STATE OF NORTH CAROLINA
DEPARTMENT OF TRANSPORTATION

May 8, 2013

Subject: **Response to On Hold Letter** for request for Section 401 Water Quality Certification Modification, Wilmington Bypass from north of US 74/76 in Brunswick County to US 421 in New Hanover County. DWQ Project No. 10-0867v.4. TIP R-2633B.

Reference: NCDOT Modification Request, dated April 3, 2013
NCDWQ On Hold Letter, dated April 19, 2013, received April 26, 2013

PERMIT DRAWING
SHEET 20 OF 73
Revised 1/20/15

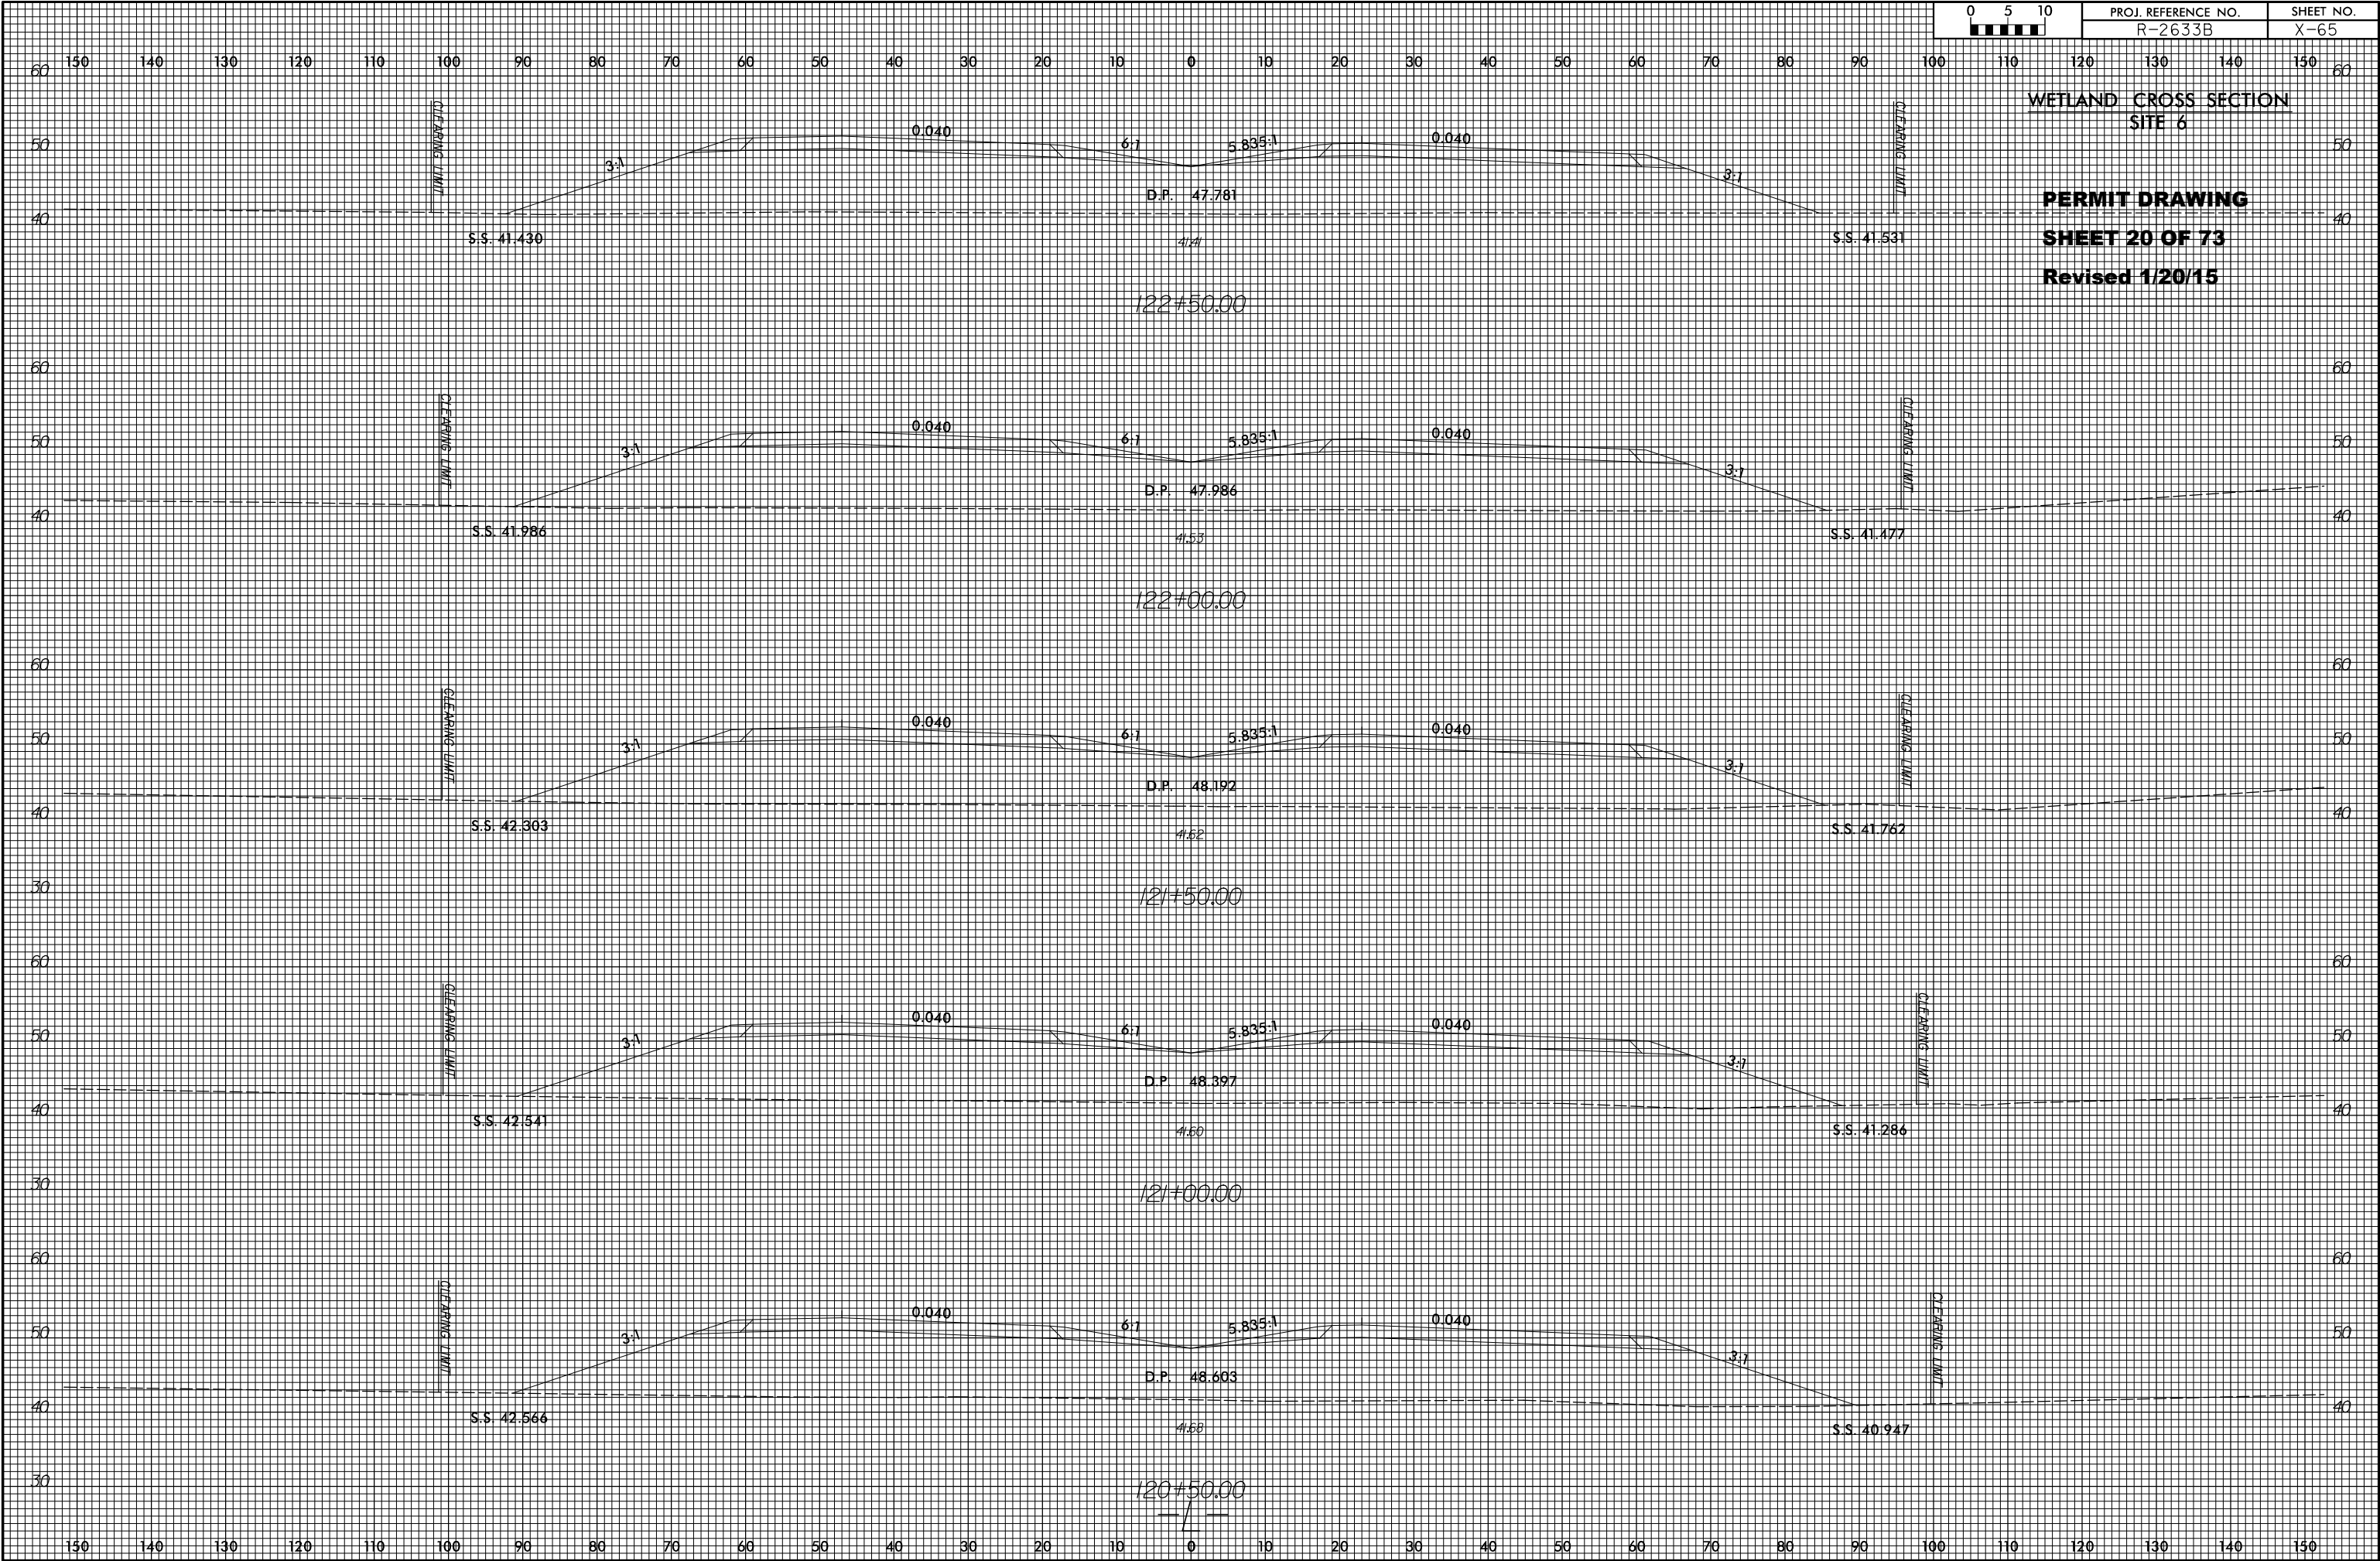
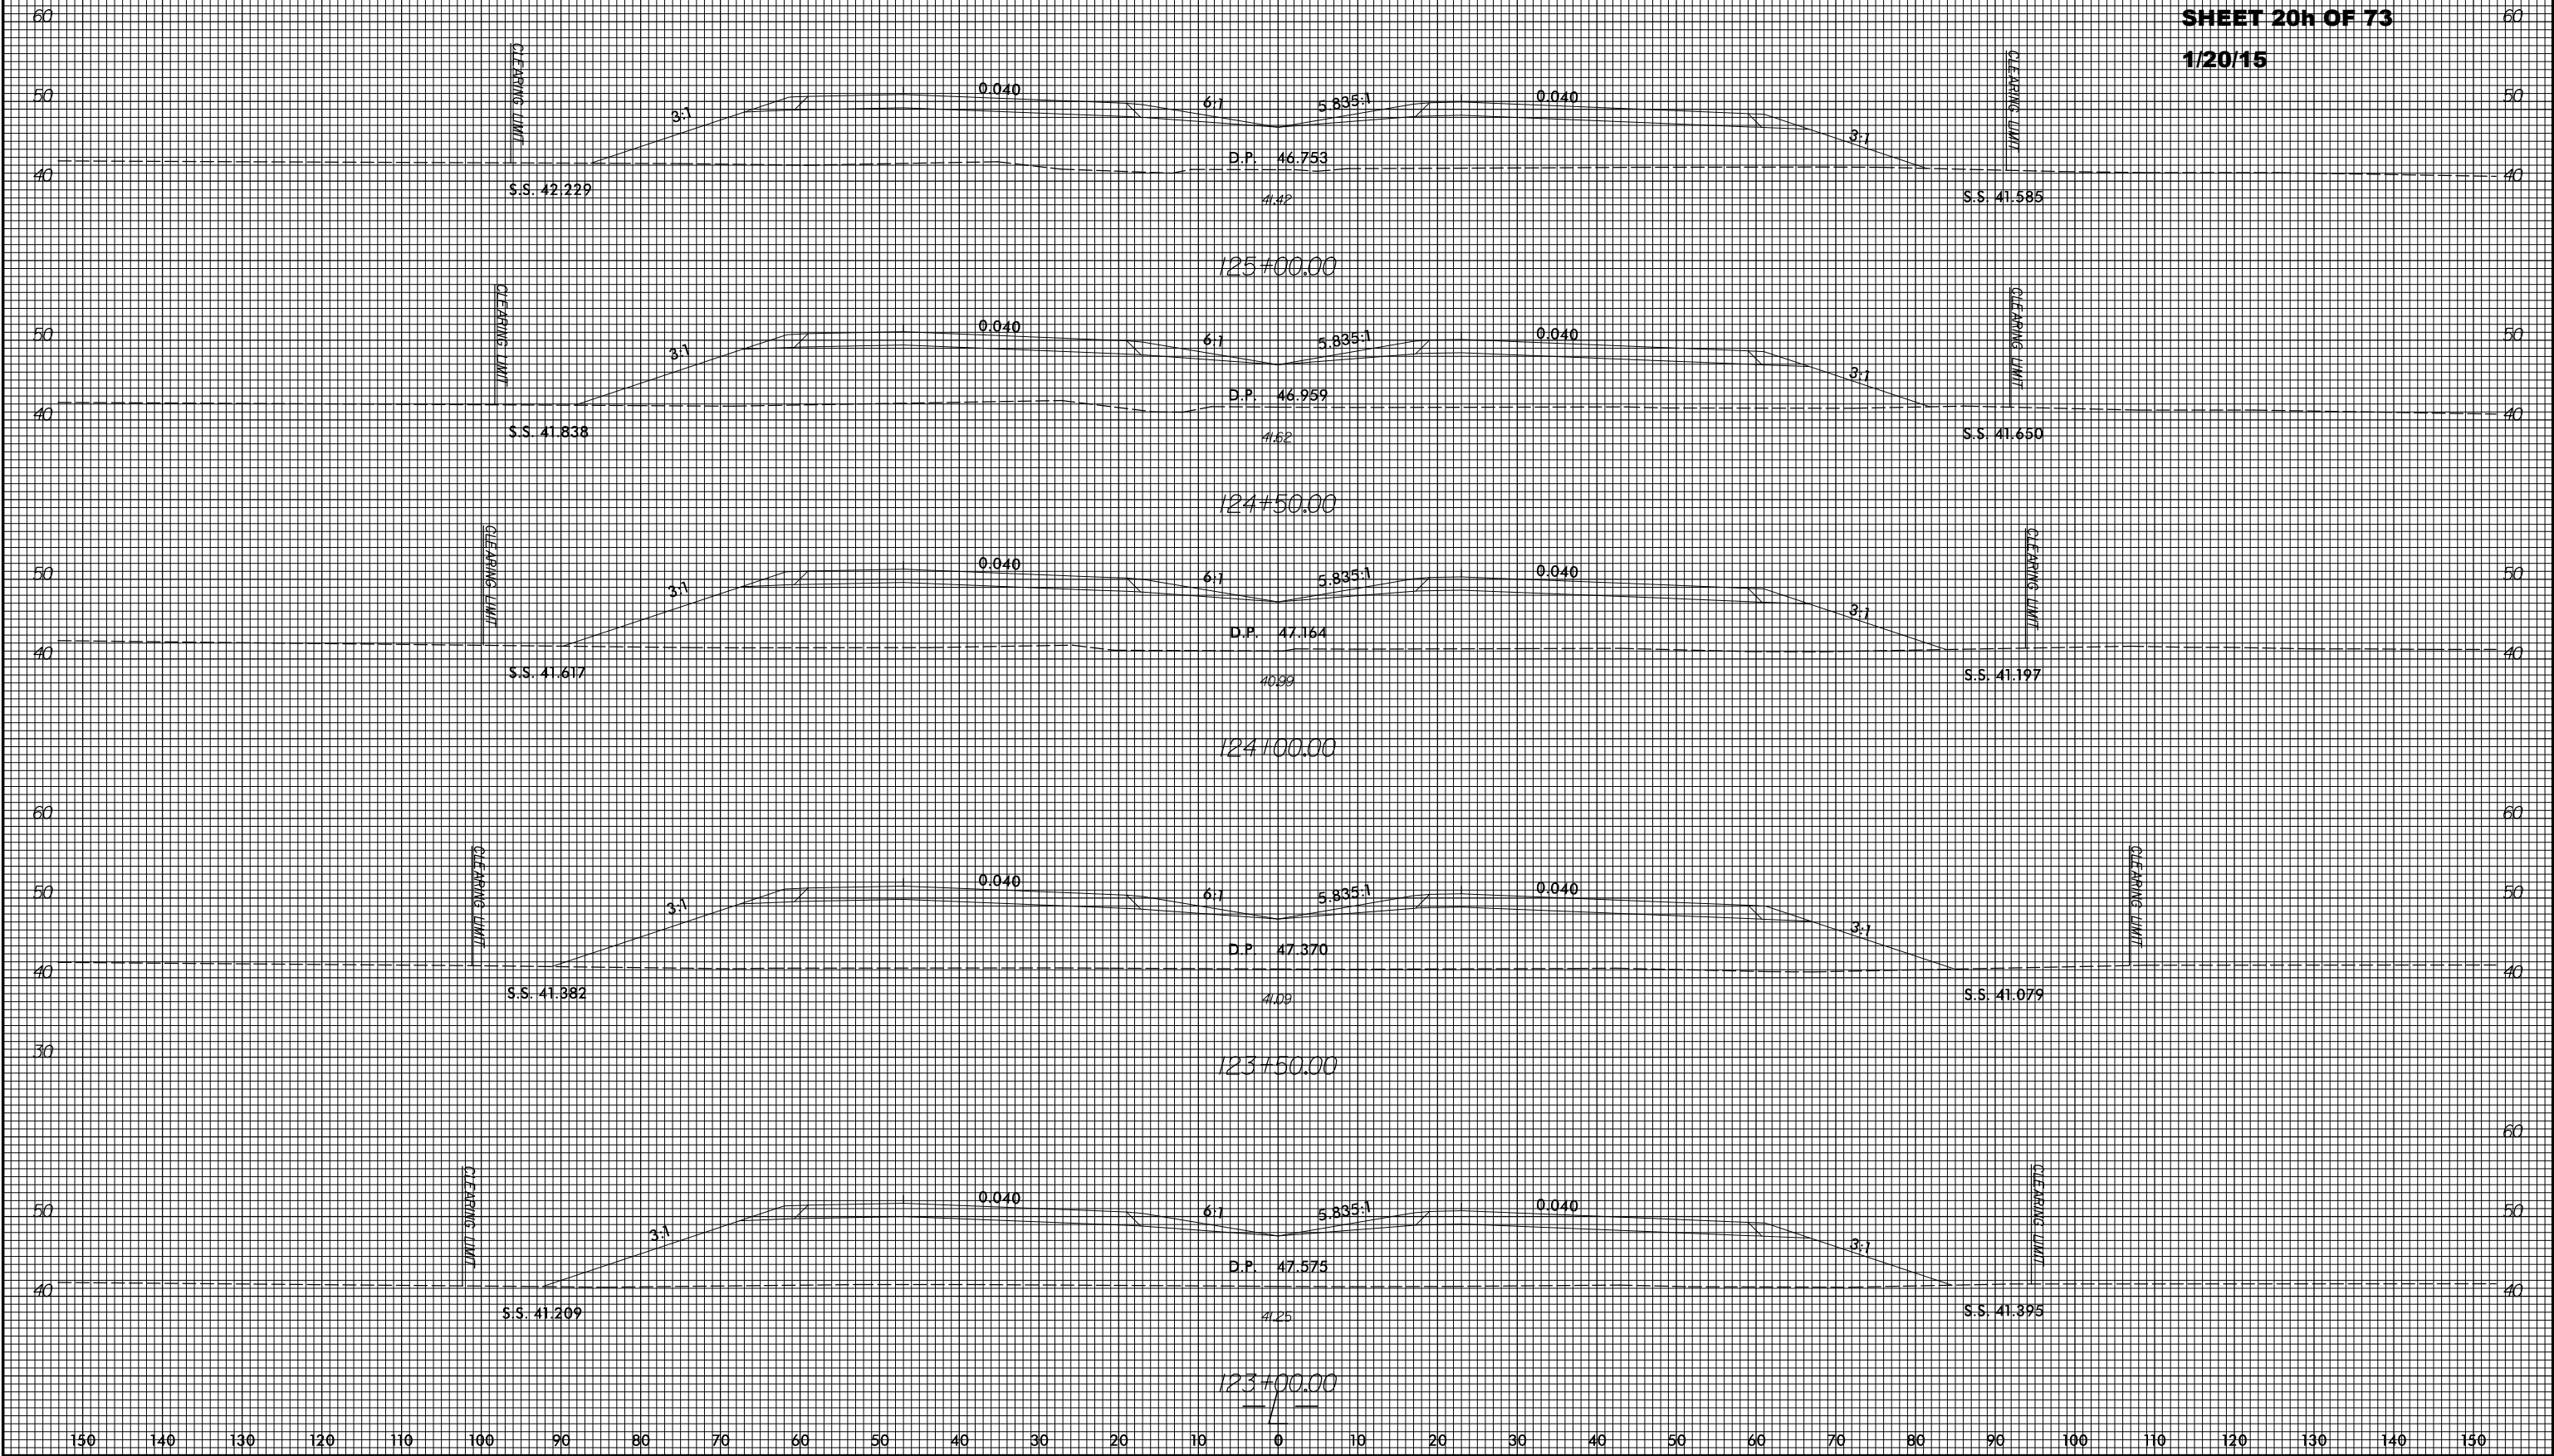
2. Site 6 – no cross sections were provided for the wetland impacts between Sta. 109+28 to 118+00 and 123+00 to 135+00. Please provide these cross sections.

3. Your application states in the "Avoidance and Minimization" section that 3:1 slopes will be used in wetland areas to minimize wetland impacts. Upon review of the application there are several cross sections that show greater than 3:1 slopes. Please correct.

Representative cross sections were provided in the application. Nevertheless, additional cross sections are enclosed, providing a larger sampling of cross sections in jurisdictional areas.

Sites 3, 5 & 6 permit drawings, cross sections, and impact summary sheet have been revised and are enclosed. As a result, proposed permanent fill has decreased at these sites by 1.42 acres. Additionally, we will submit a revised request to EEP for an updated acceptance letter.
